Appeal Decision

Appeal Ref: APP/R5510/D/21/3284150

20 Vine Lane, Uxbridge UB10 0AY

**DESCRIPTION:**  
PROPOSED LOFT CONVERSION AND  
DORMERS IN ROOF SLOPE

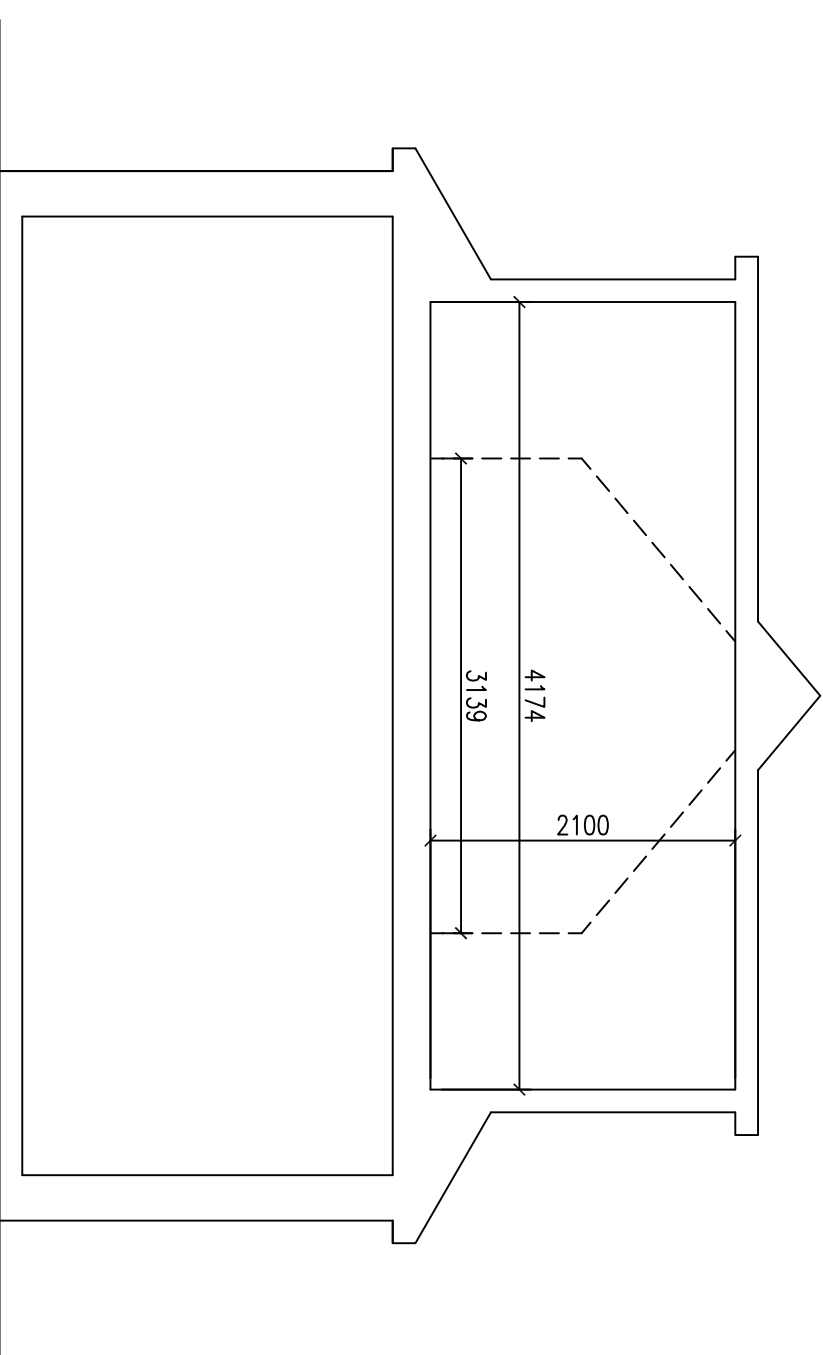
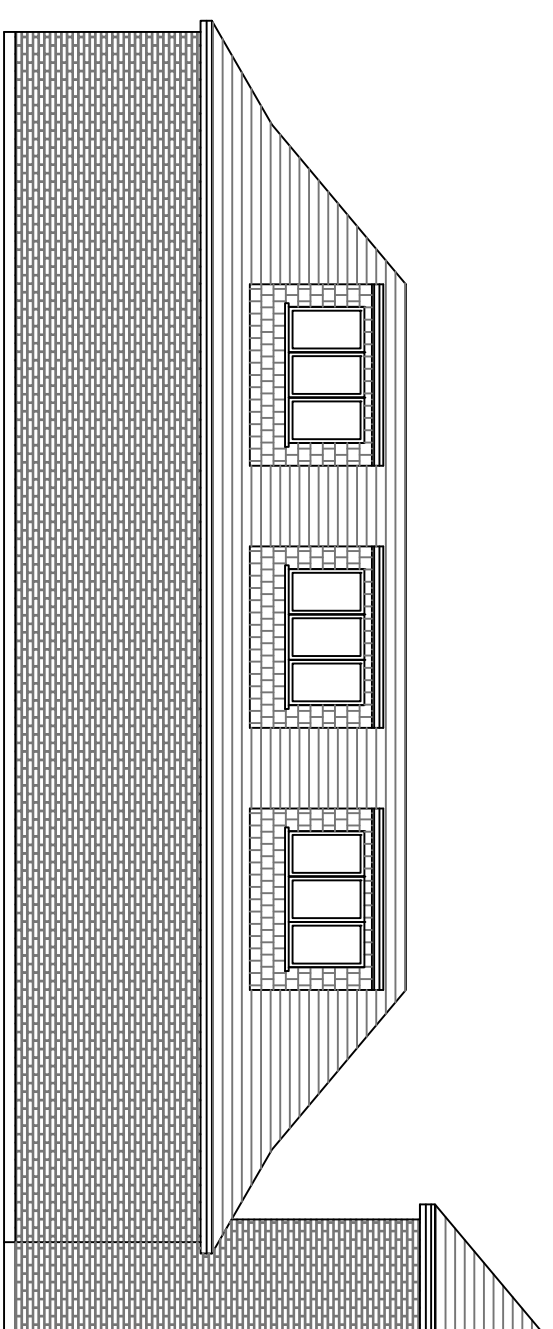
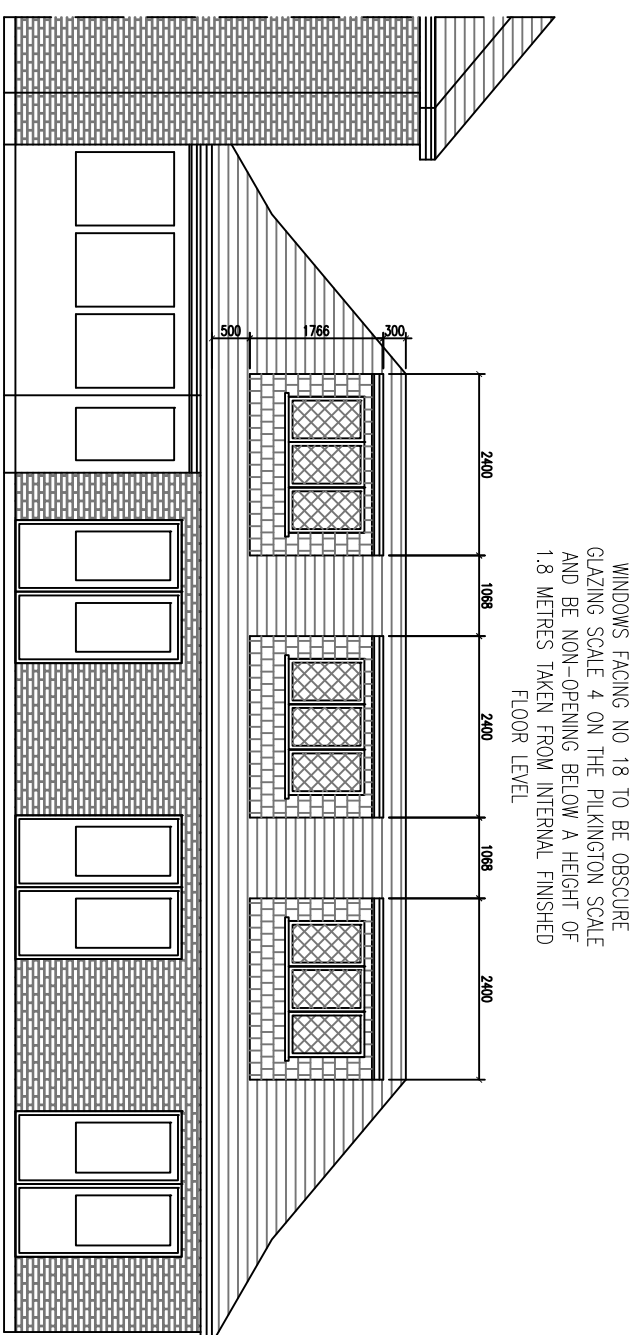
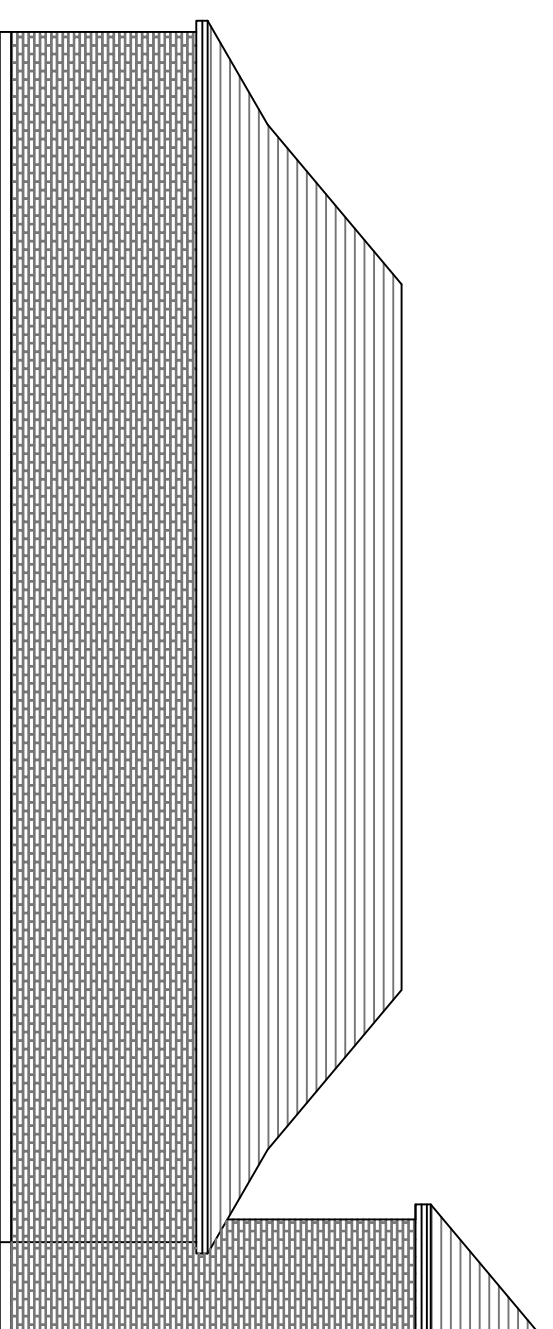
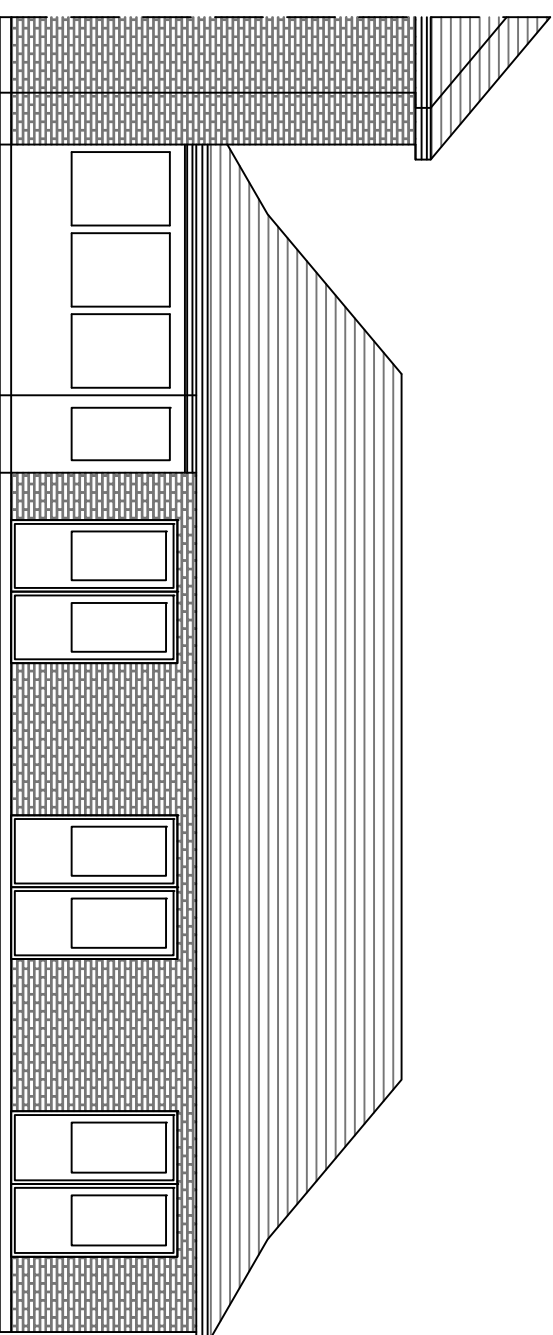
5. The single storey building to which the proposed dormers would be added is situated to the rear of the appeal property and projects parallel to the adjacent Chetwyn Drive. Consequently, the 3 proposed dormer windows to the southern elevation would be screened from the road and largely only visible from view points to the rear of the appeal property.

6. I saw at the site visit that the northern elevation of the existing building, while referred to as the rear elevation on the submitted plans, would nonetheless face on to Chetwyn Drive. The existing established trees to this boundary would provide some screening but the dormers would otherwise be visible from the street.

PROPOSED ROOF PLAN 1:100 SCALE

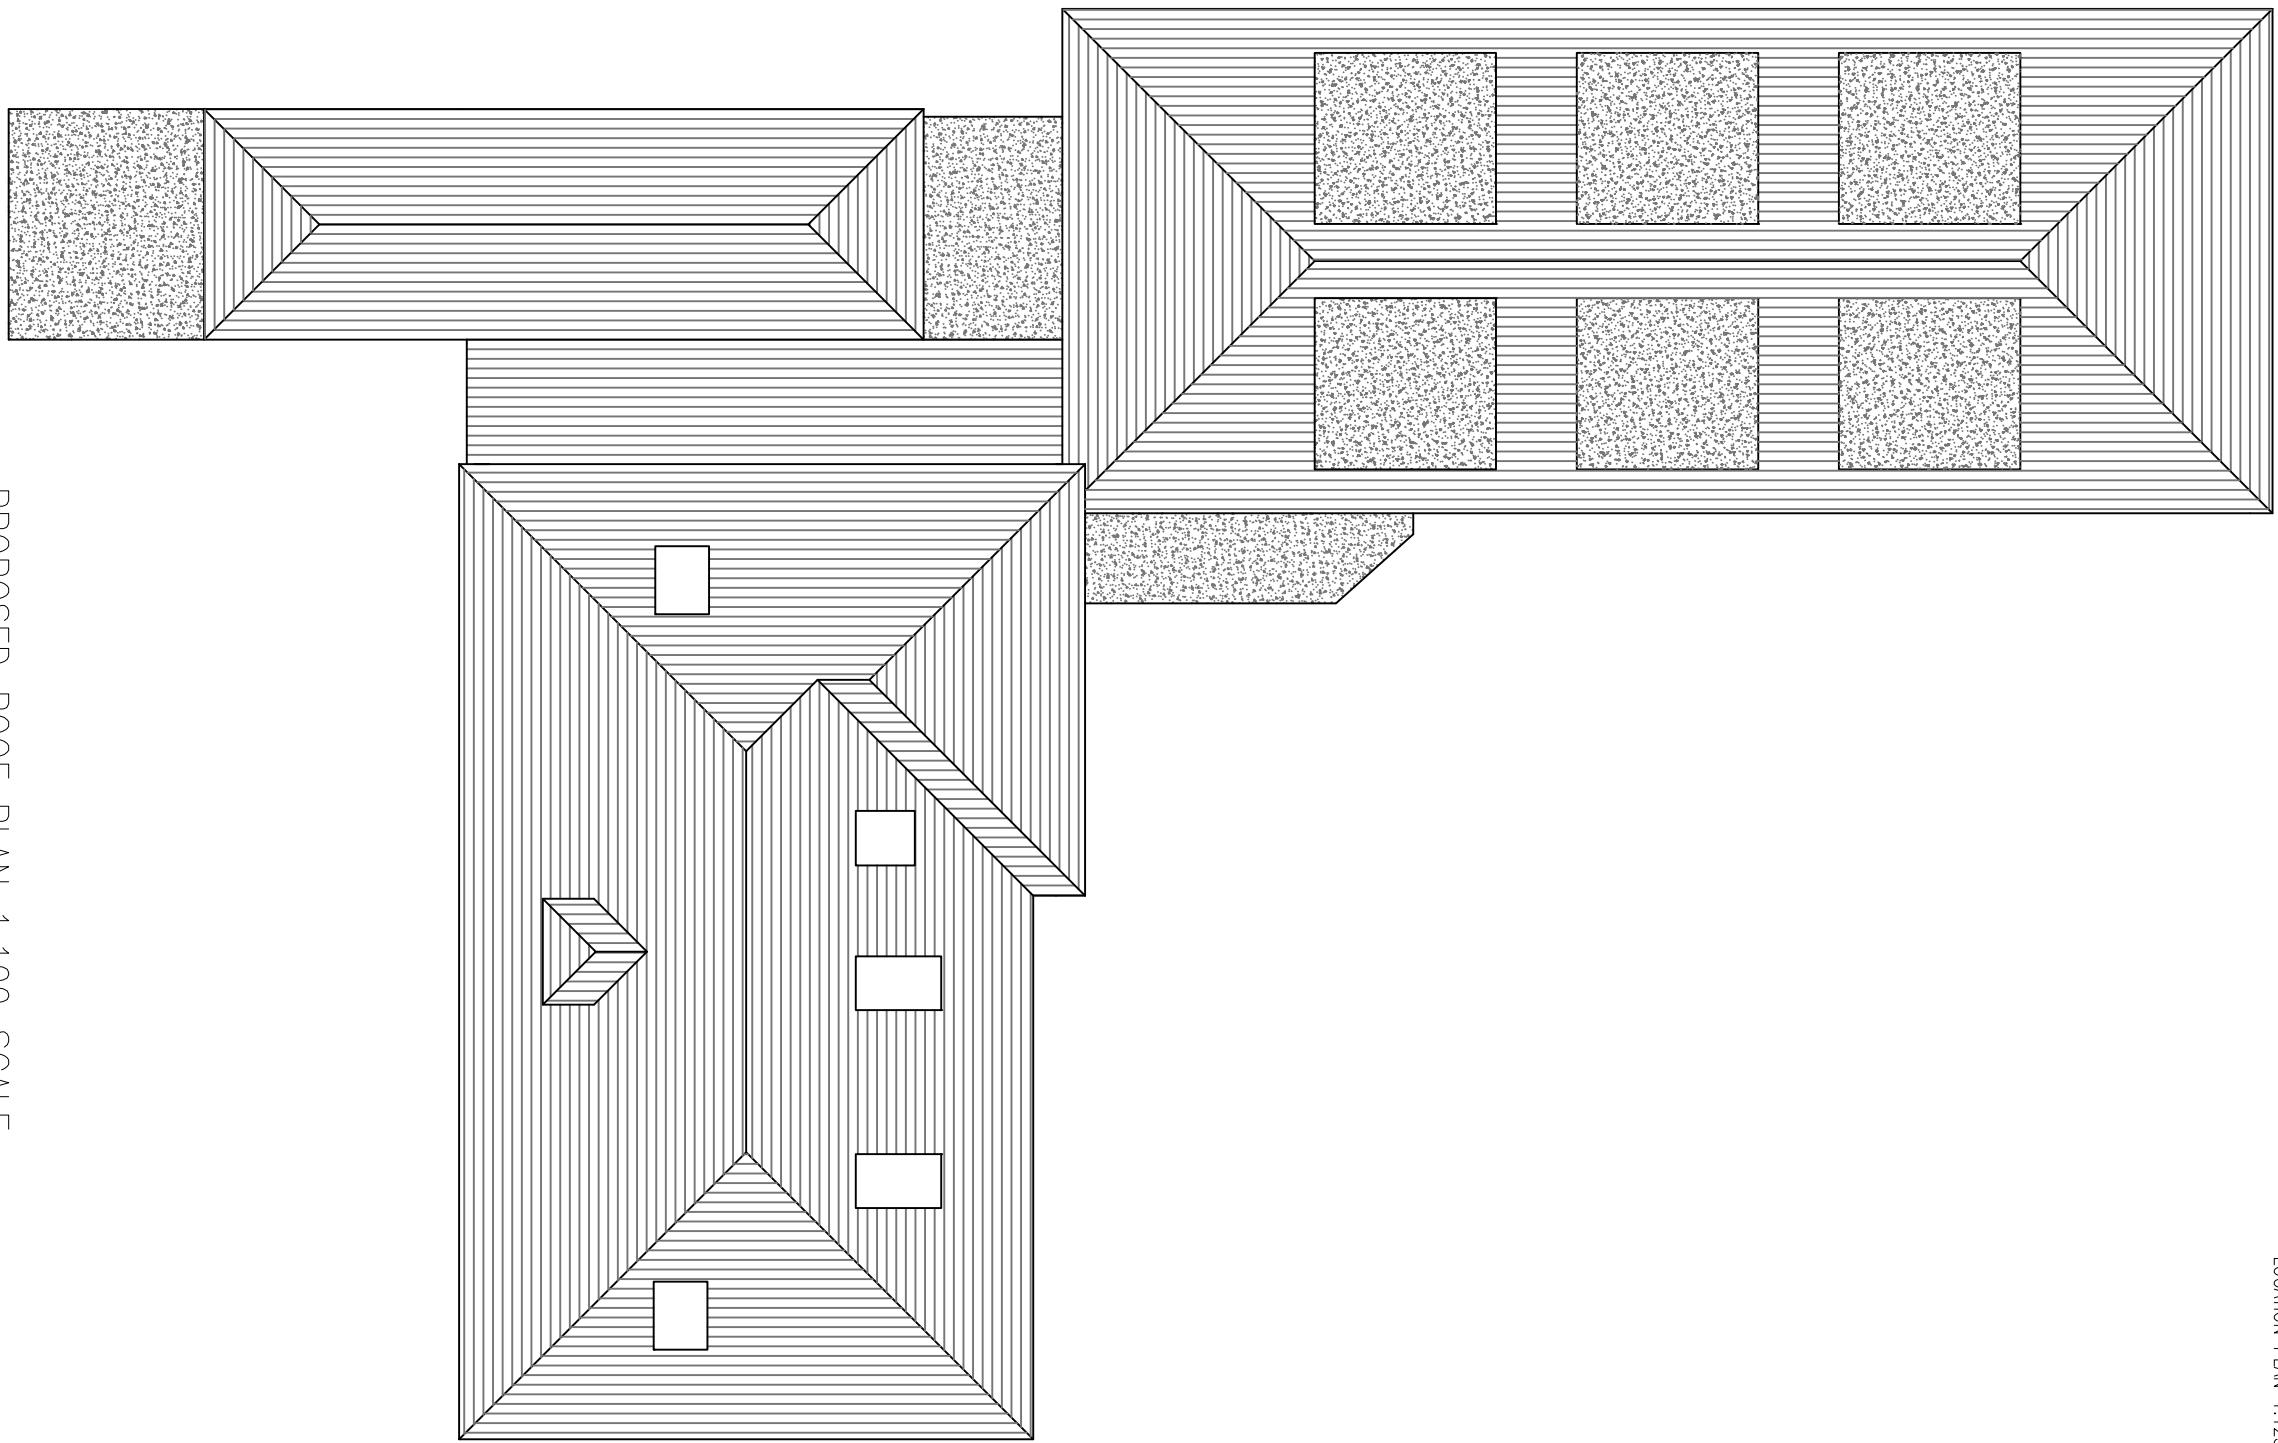
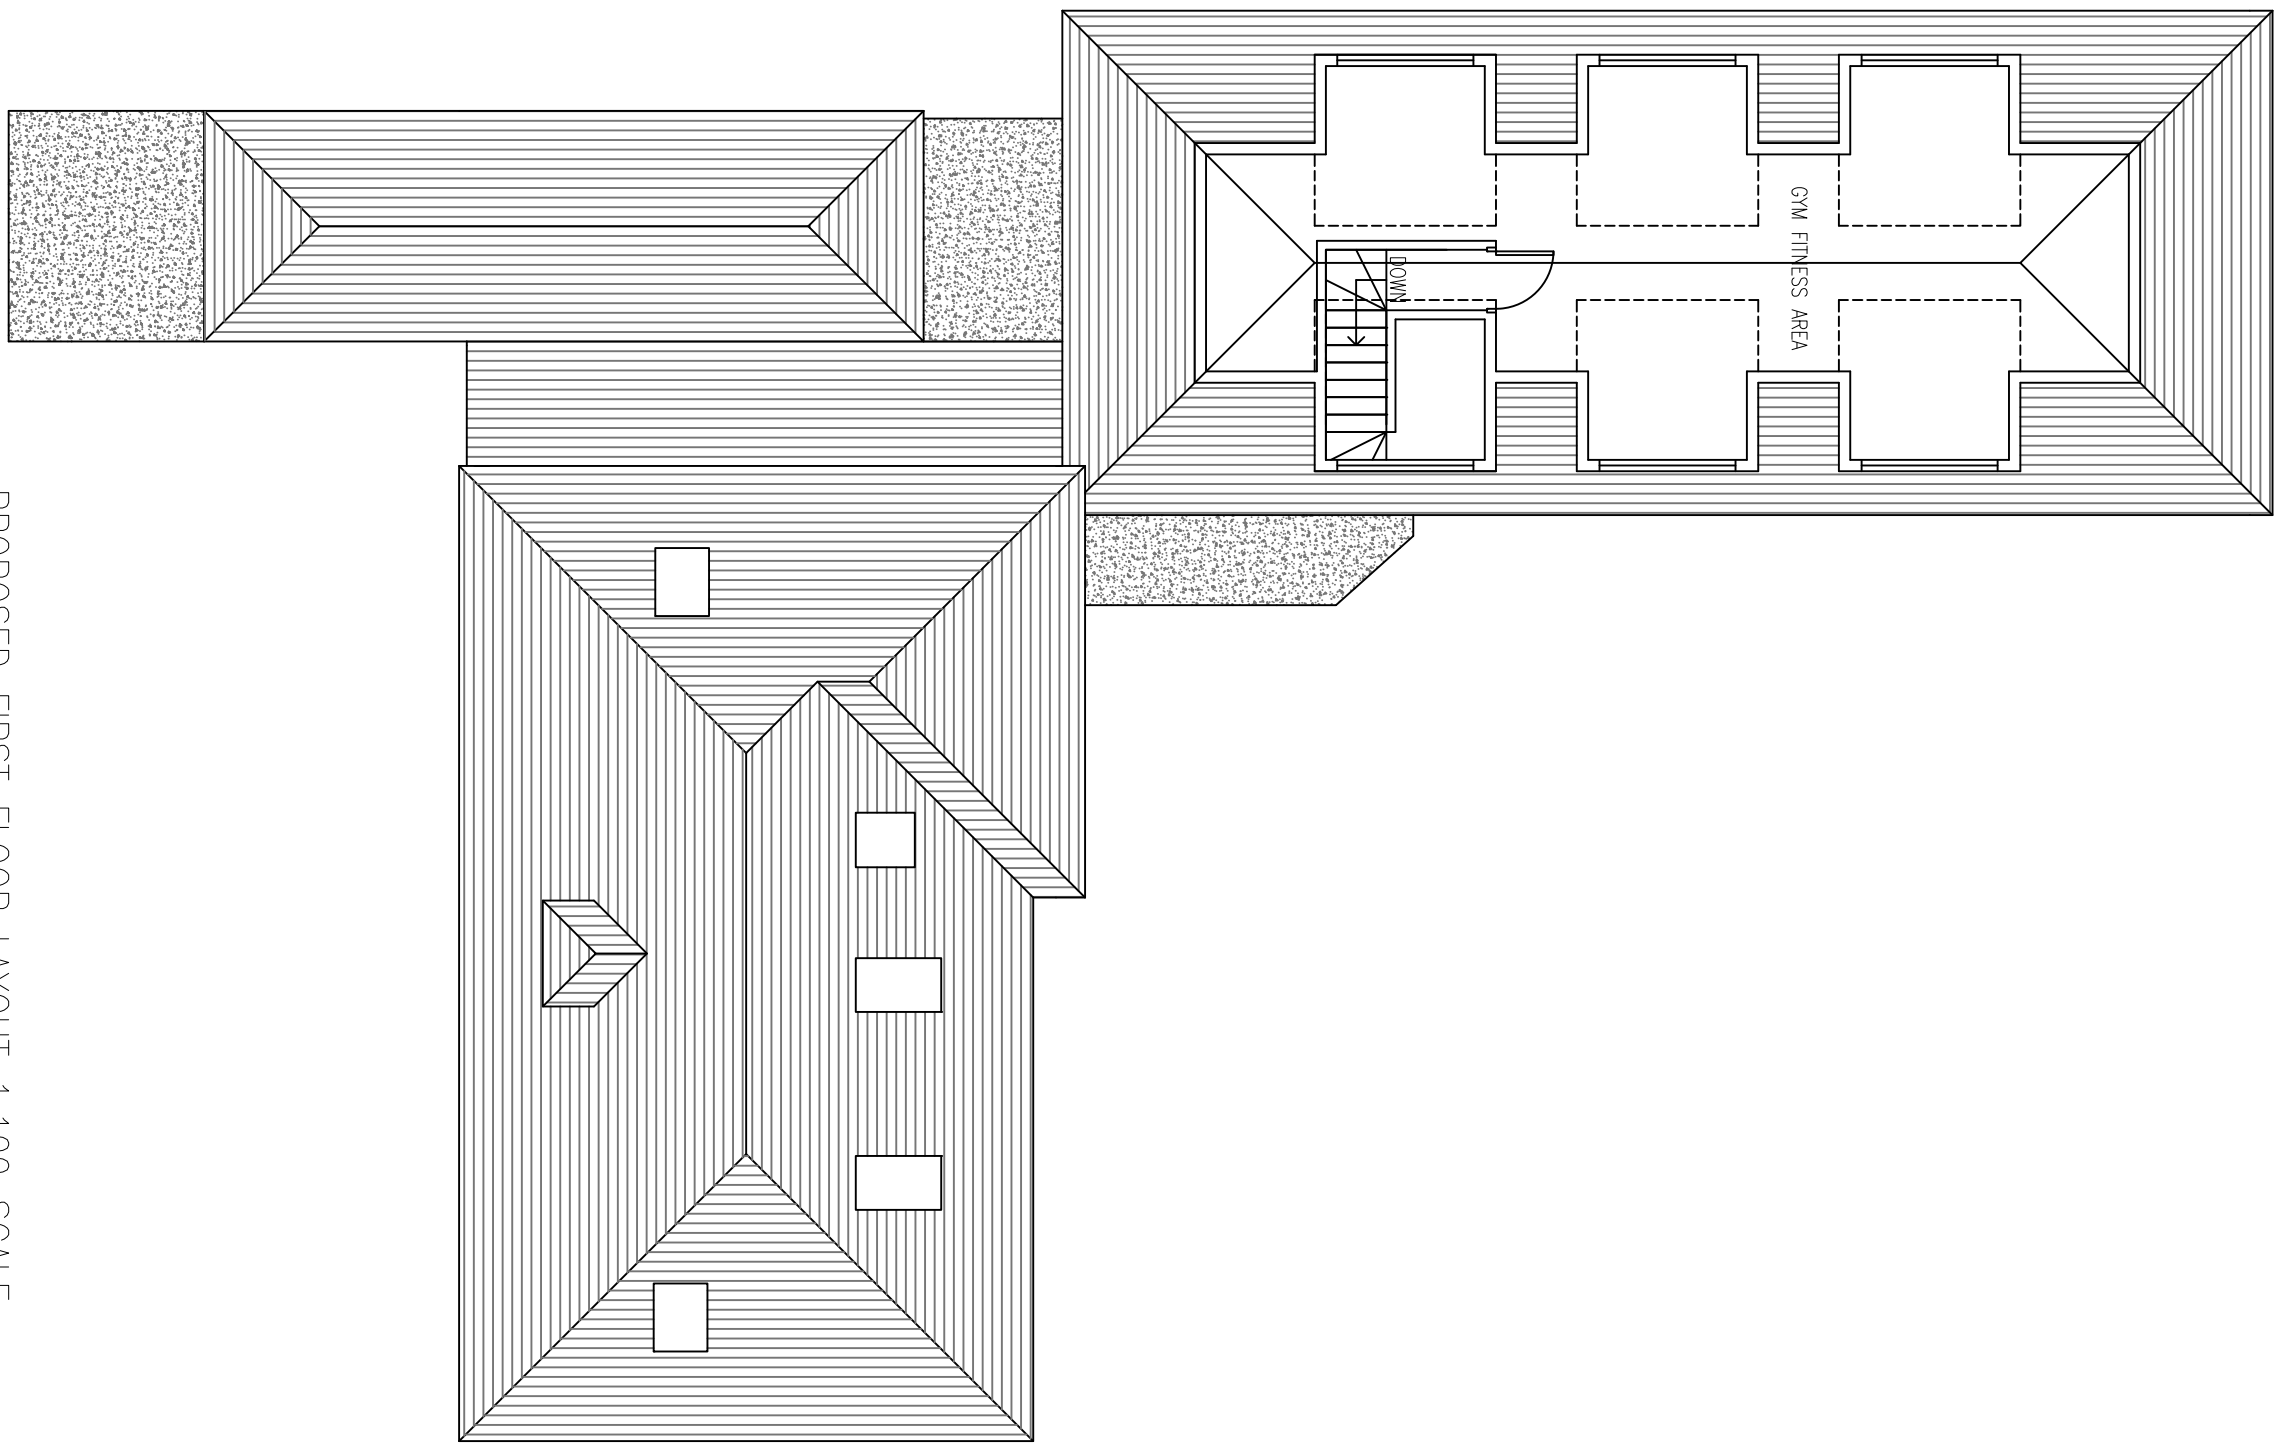
7. Furthermore, the submitted plans show that, as a result of the combination of the size, scale and number of the flat roofed dormers in proportion to the modest scale of the existing single storey building, the appeal scheme would fail to appear as subordinate to the existing property.

8. The appellant details that "the size and spacing of dormers have been designed to provide adequate separation between the dormers so that not to create one single bulk dormer". Nonetheless, the submitted plans show that the dormers would dominate the existing roof structure.
